Application No: LU/200/25/PL
Site Address: Pavement o/s 63 High Street Littlehampton BN17 5EJ
Description of works: Removal of associated existing BT payphone(s) and kiosks and installation of 1 No BT Streethub Unit. This application affects the setting of listed buildings and is in CIL Zone 4 (Zero Rated) as other development.

This application was considered by the Littlehampton Town Council's Planning and Transportation Committee on Monday 3 November 2025. The committee objected to the application, an extract of the minutes of the meeting are set out below:

88.1.1. Planning Application LU/200/25/PL Pavement o/s 63 High Street

EXISTING AND PROPOSED  
ELEVATIONS

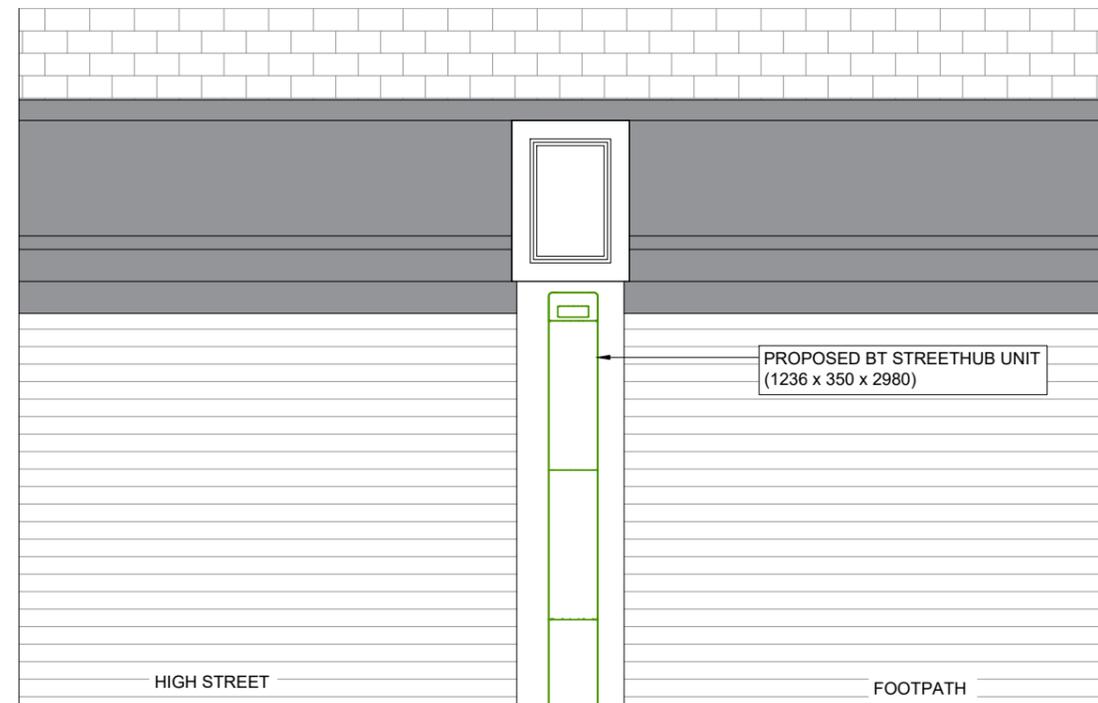
The Committee considered the planning application for the removal of existing payphone kiosks, and the installation of a BT Streethub advertising unit outside 63 High Street. The committee objected to the application due to the unsuitable site placement of the new BT Streethub unit. While the committee supported the removal of the existing payphones, and would in future consider supporting their replacement, they maintained their objection on the grounds that the site's development would have a negative visual impact on the street scene and detract from the newly regenerated High Street. Its position would significantly impact accessibility and impinge on the ability to deliver events as well as disturb activities such as the weekly market, all of which supports the economic vitality and safe environment of the High Street as set out in the Town Centre Strategy.
